Proposed Concorde Residential Development, Naas Road, Walkinstown, Dublin 12

Stage 1/2 Road Safety Audit

1	AUDIT INFORMATION	
1.1	Title	RSA CONCORDE S1/2
1.2	Audit Reference Number	RSA CONCORDE S1/2 KS 291
1.3	Project Code	CONCORDEQA
1.4	Date Audit Completed	11 th January 2019
1.5	Audit Team	
	Team Leader	Ken Swaby, ILTP
	Team Member	Mark Andrews, ILTP
1.6	Information Received

| DRAWING No. | CCRD-BMD-00-ZZ-DR-C-1004 | ISSUE | PL4 |

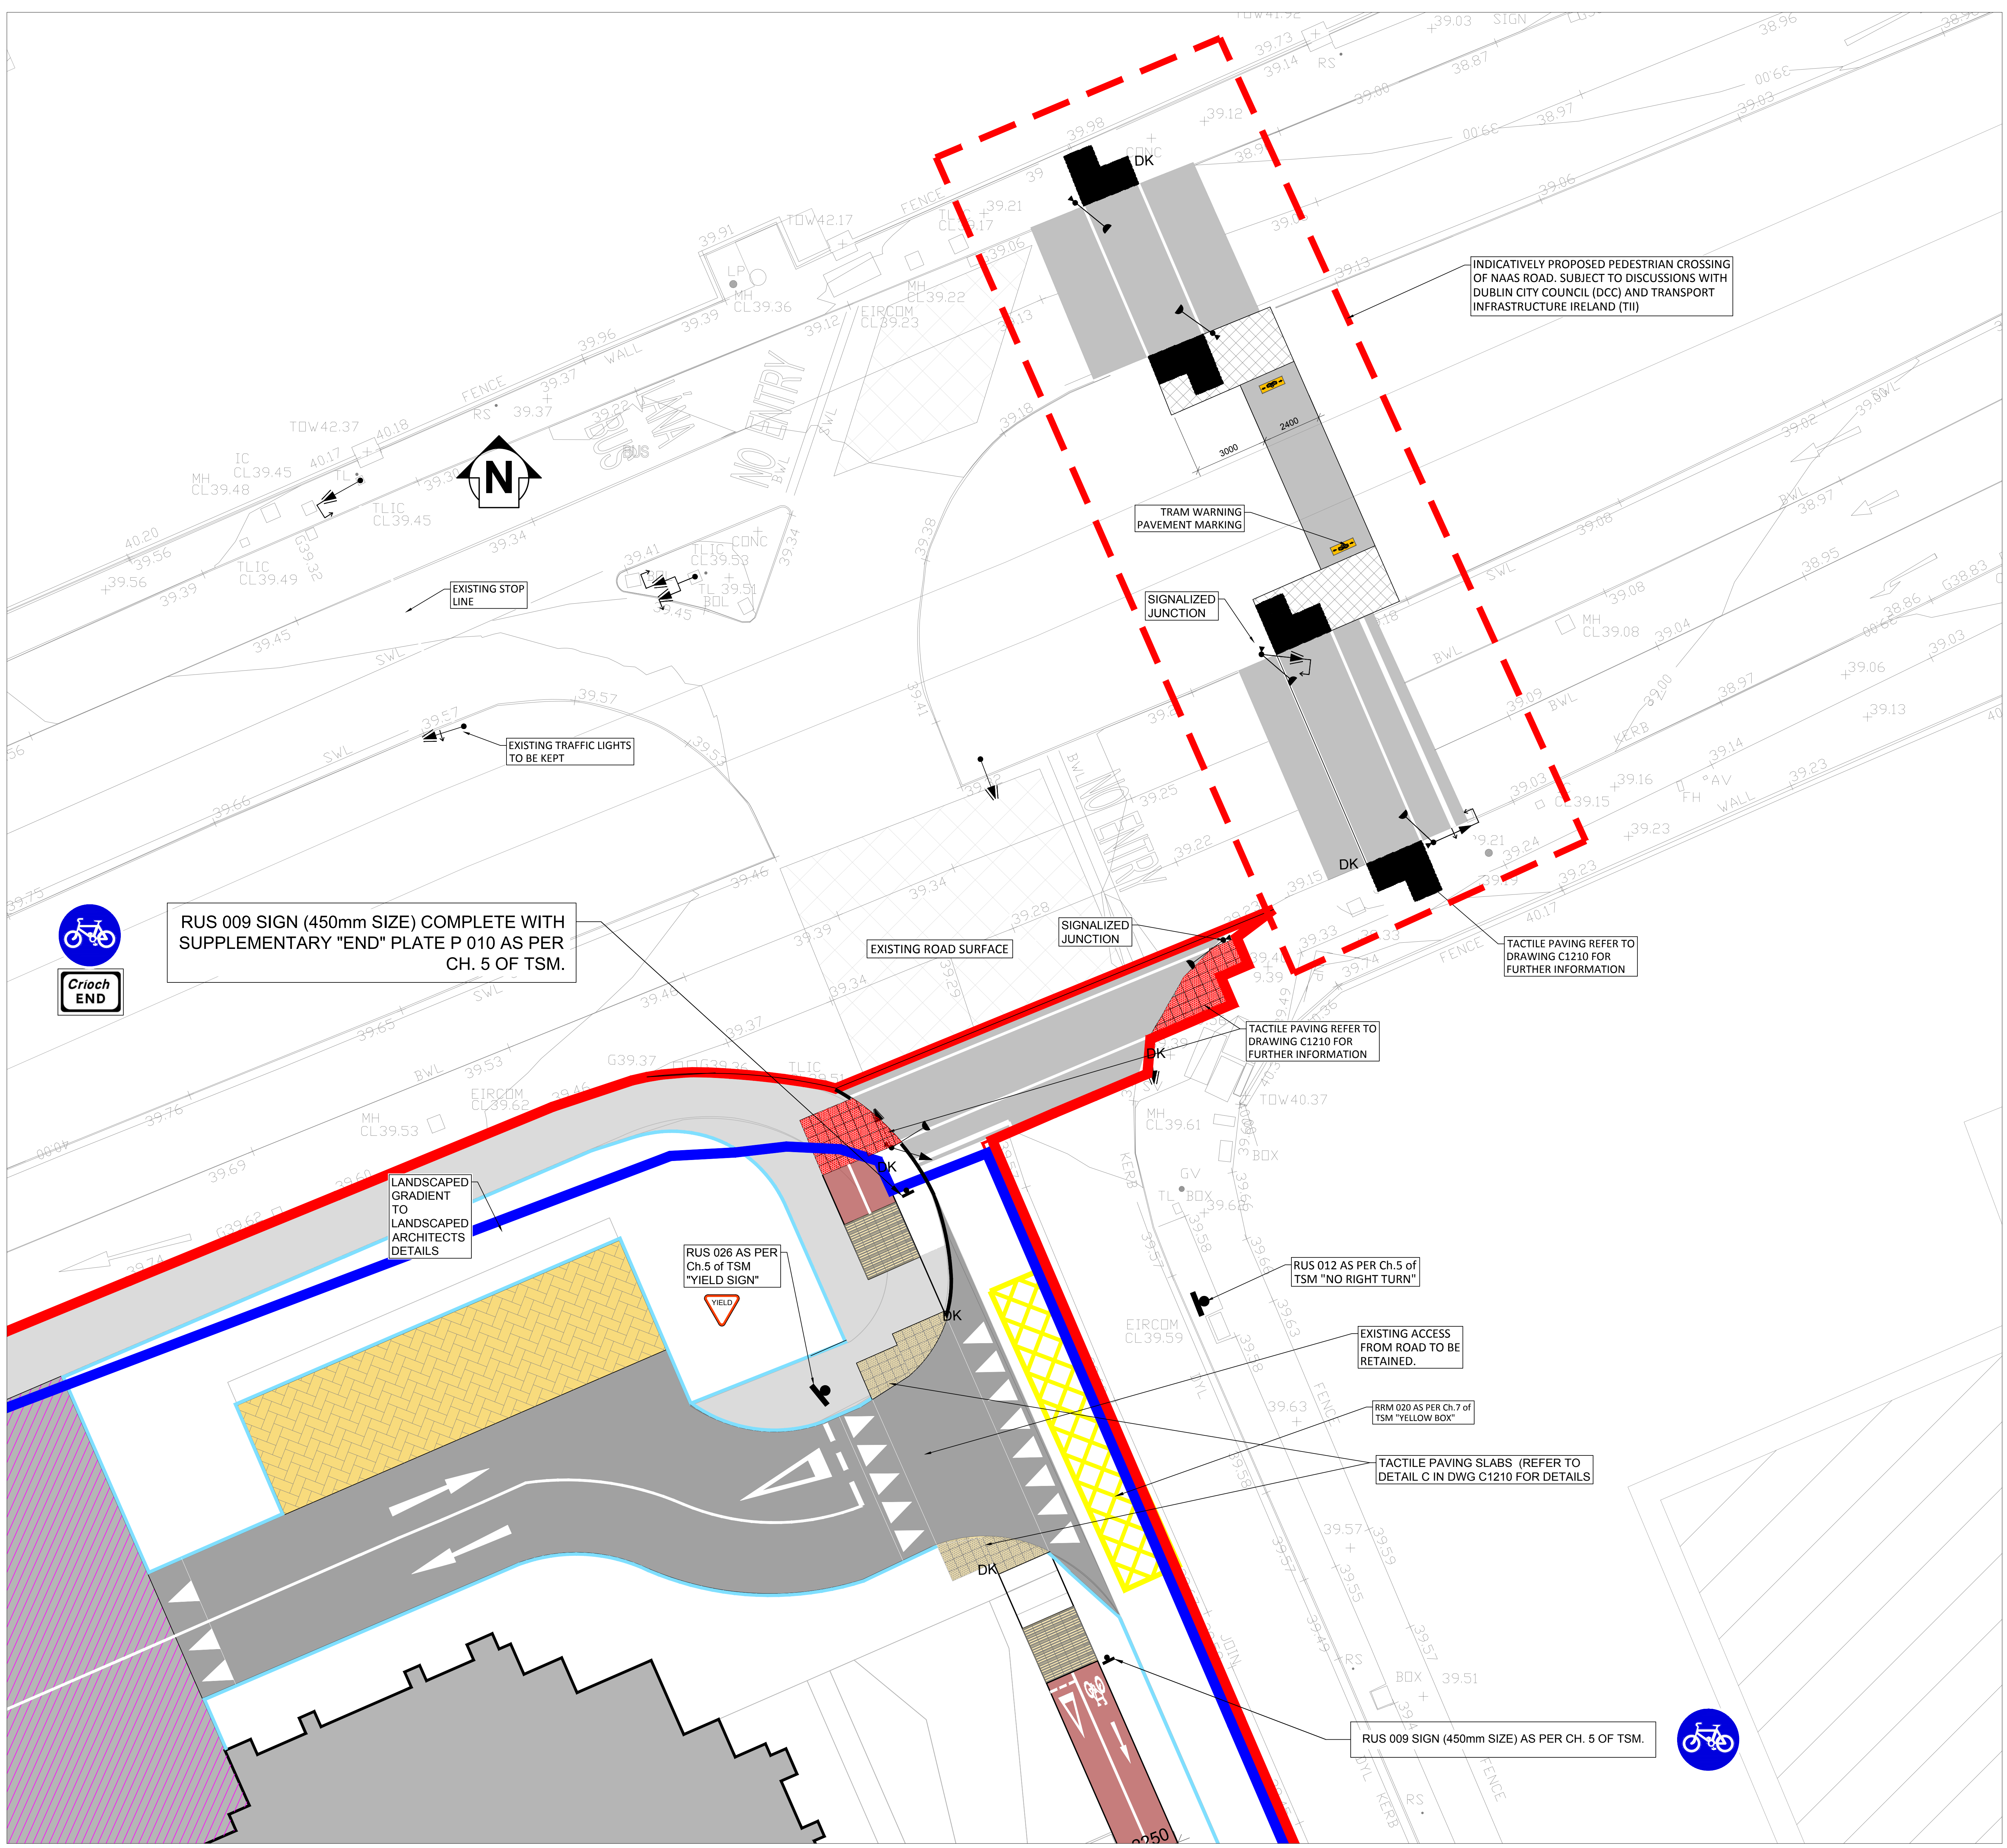
The information provided for audit shows a proposed vehicular access junction to the development in close proximity to the existing Concorde Industrial Estate Access Road / Naas Road signalised junction. It is further noted that the proposed Stop Line to the Naas Road junction is within the mouth of the proposed development access junction. This configuration presents various potential conflicting turning movements within the confines of the junctions.

It is recommended that the design team ensures that there is appropriate separation between the Concorde Industrial Estate Access Road / Naas Road signalised junction and proposed development access junction to minimise potential vehicular conflict points.

It is further recommended that the design team ensures that the proposed STOP line and pedestrian crossing at the Naas Road junction are appropriately located to minimise potential vehicular conflict points. This may require inclusion of a pedestrian crossing refuge island and/or reduced kerb radii.

The information provided for audit shows a proposed vehicular access junction to the development in close proximity to the existing Concorde Industrial Estate Road / Naas Road signalised junction. Without appropriate visibility between the intersections it is possible that traffic may emerge without appropriate knowledge of traffic at other intersections.

It is recommended that the design team ensures that the intersections have adequate intervisibility and that the proposals do not have features that would restrict the visibility of drivers utilising the intersections.

Para No. in Report	Problem Accepted (Y/N)	Recommendation Accepted (Y/N)	Comments / Alternative Measures (Describe)	Alternative Measures Accepted by Auditor? (Y/N)
4.1.1	Y	Y	PEDESTRIAN CROSSING LOCATED CLOSER TO NAAS ROAD JUNCTION. ACCESS ROAD TO DEVELOPMENT MOVED FURTHER SOUTH TO MAXIMISE SEPARATION. ADDITIONAL ROAD SIGNAGE AND CLARIFICATION NOTES ADDED	Y
4.1.2	Y	Y	ADDITIONAL DETAIL INCLUDED ON DRAWINGS. DEDICATED TURNING LANES NOT CONSIDERED NECESSARY	Y
4.1.3	Y	Y	As 4.1.1	Y
4.1.4	Y	Y		Y
